Engineers Comments Regarding Surface Water Drainage

Application Reference:	BR/82/26/PL	Reviewer Reference:	ADC/EXT5/AF
Planning Officer:	Amber Willard	Date of Review:	16/07/2026
Site Name:	63 Annandale Avenue Bognor Regis PO21 2ET		
Application Description:	Demolition of the existing dwellinghouse and associated buildings, and the construction of a three-storey building comprising 9 No. self-contained flats with associated landscaping, refuse storage, bicycle storage and parking spaces. This application is in CIL Zone 4 (Zero Rated) as other development.		
Assessment Number:	1

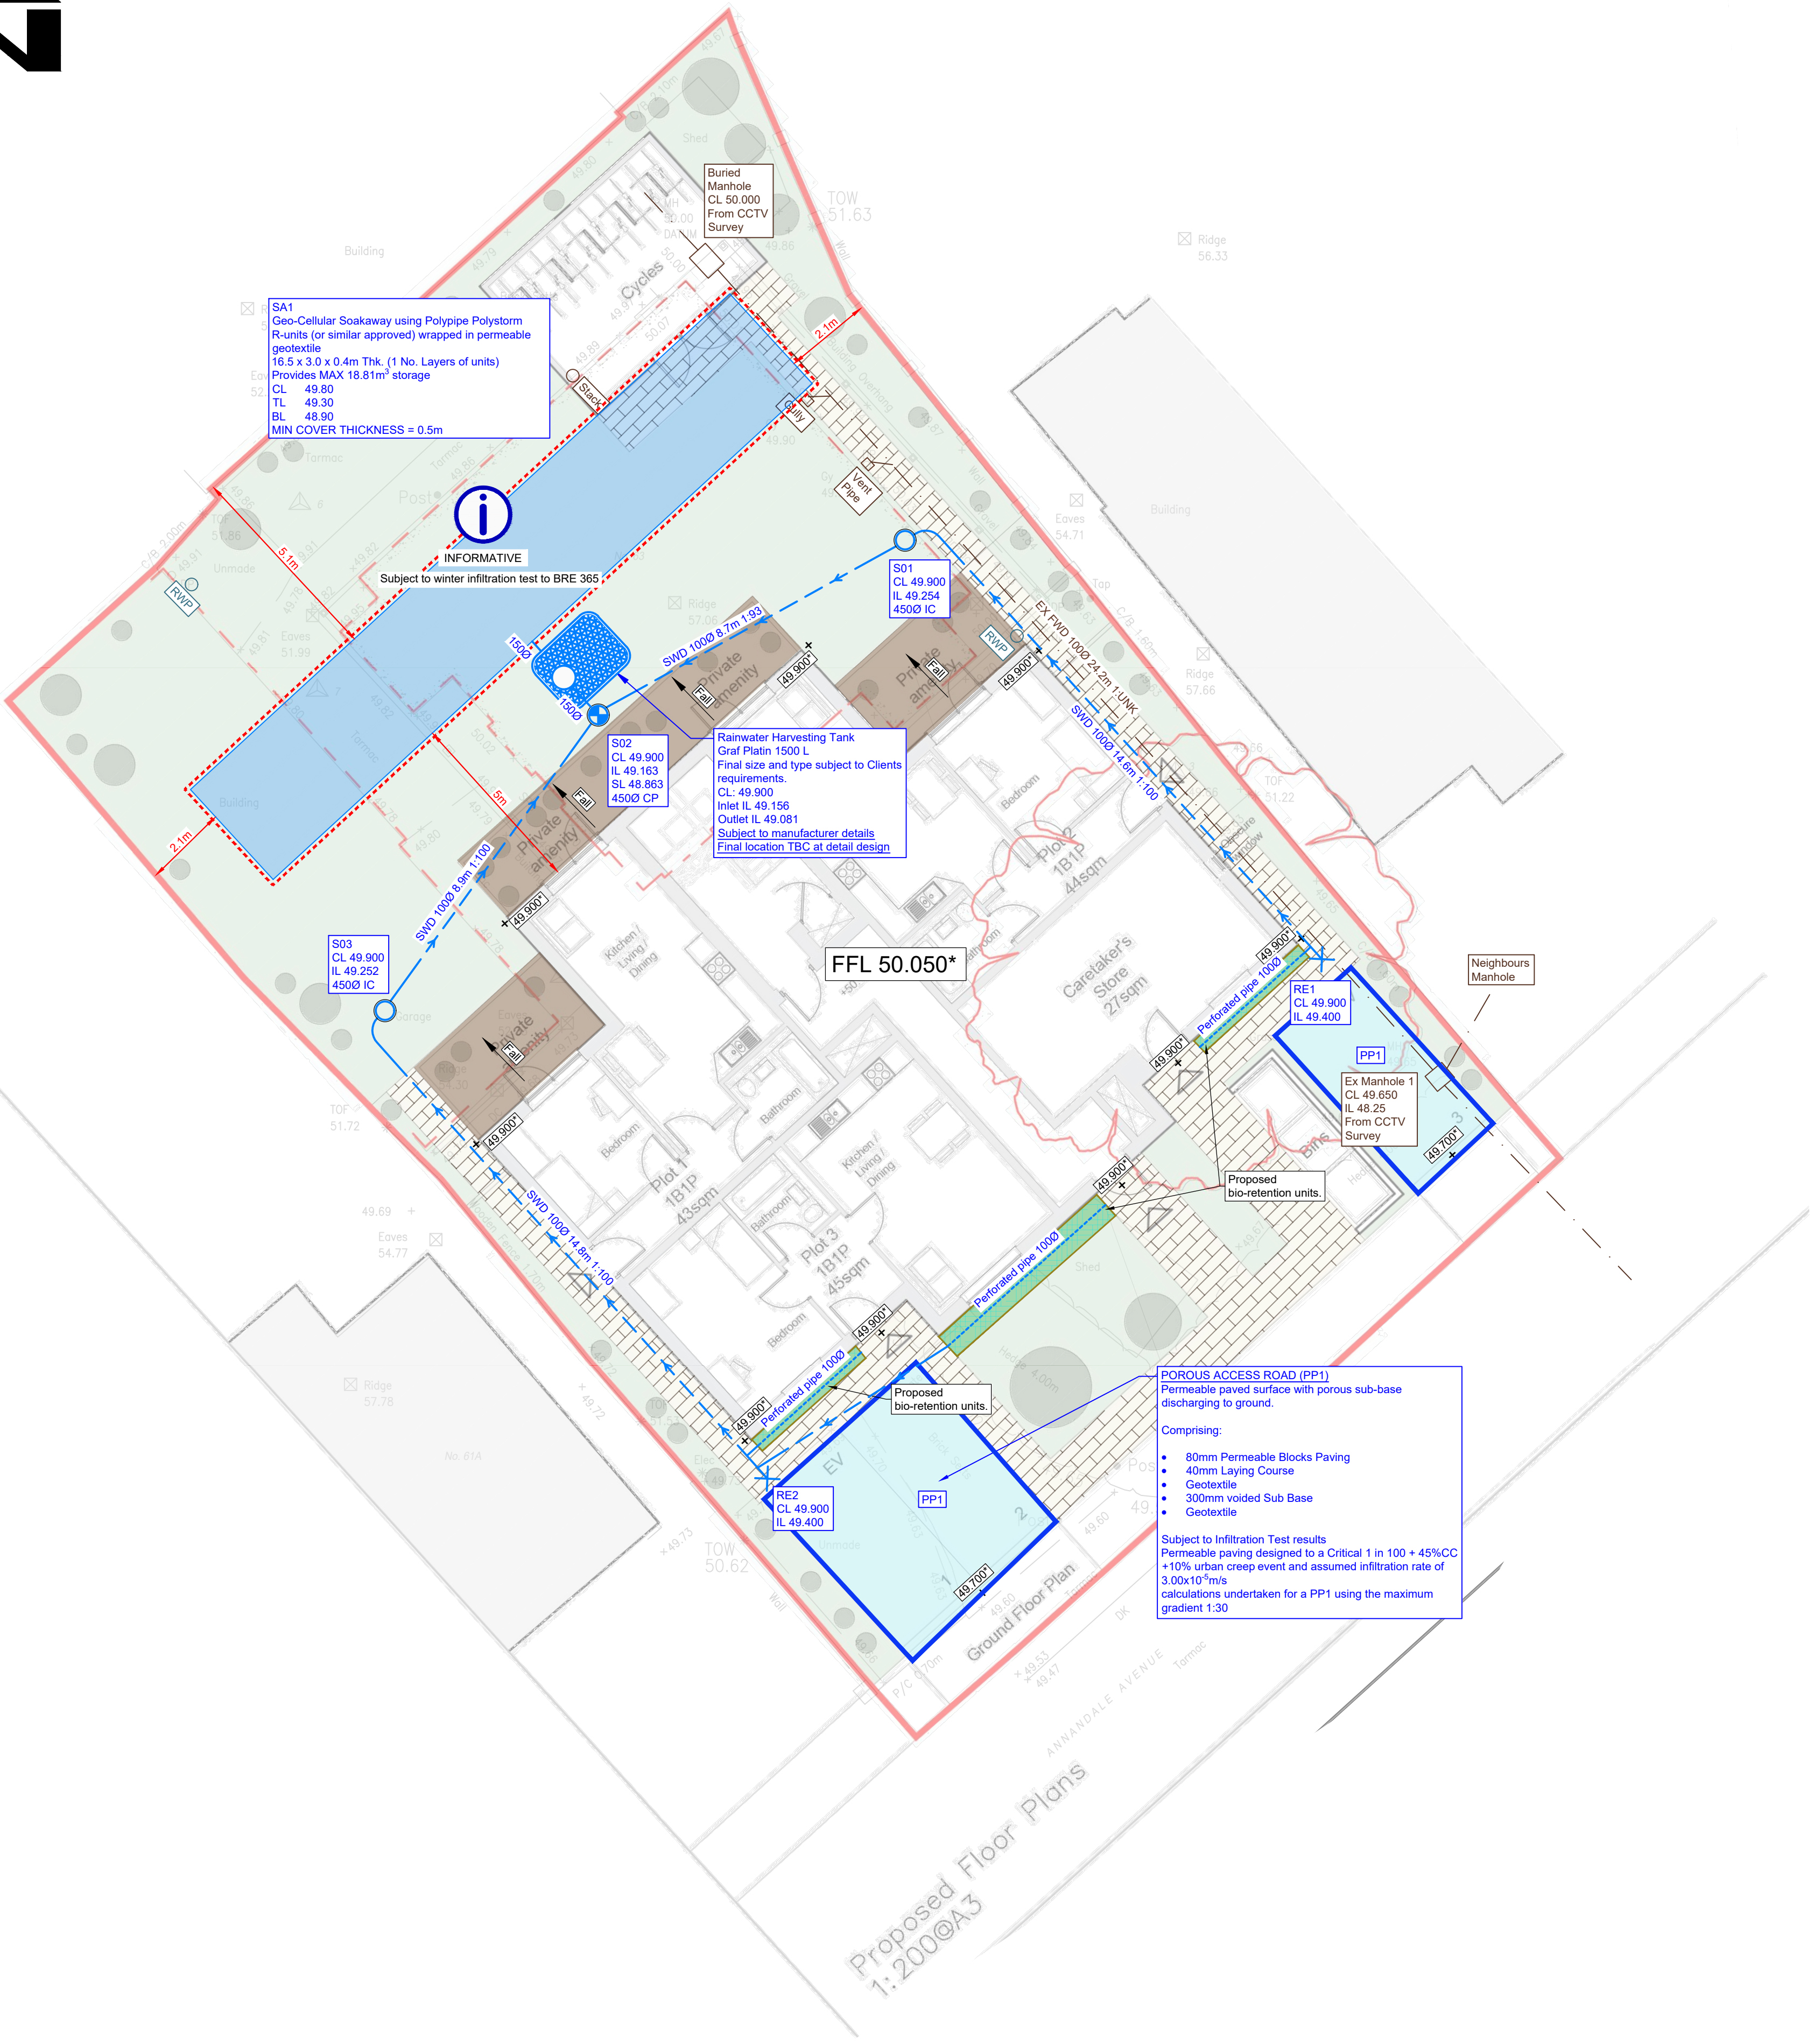
- 1.1. The proposals include a communal below ground rainwater harvesting tank of 1,500 litres which is used for landscape irrigation and is acceptable.
- 1.2. Disposal of rainwater is to ground via infiltration. This is based upon an assumed rate of infiltration and is not supported by infiltration testing or groundwater monitoring.
- 1.3. Ground Investigation is not provided and therefore does not meet the standards set out in the ADC ground investigation checklist requirements. Guidance is provided on ADC webpages here: <https://www.arun.gov.uk/designer-checklists>
- 1.4. Further information is required to confirm the design is in accordance with the requirements of the NSfS (Standard 1). Therefore, we **object** to the application.

- 2.1. The current design proposal achieves interception drainage through infiltration to ground. However, further information is required to evidence that this solution is feasible and further measures for interception drainage may be required if infiltration is not feasible, which may affect the plan layout.

- 3.2. However, the infiltration coefficients are based upon assumed infiltration rates and should be based upon sites specific values obtained through infiltration testing at similar depth and location to the proposed soakaway. See comments above on Runoff Destination.
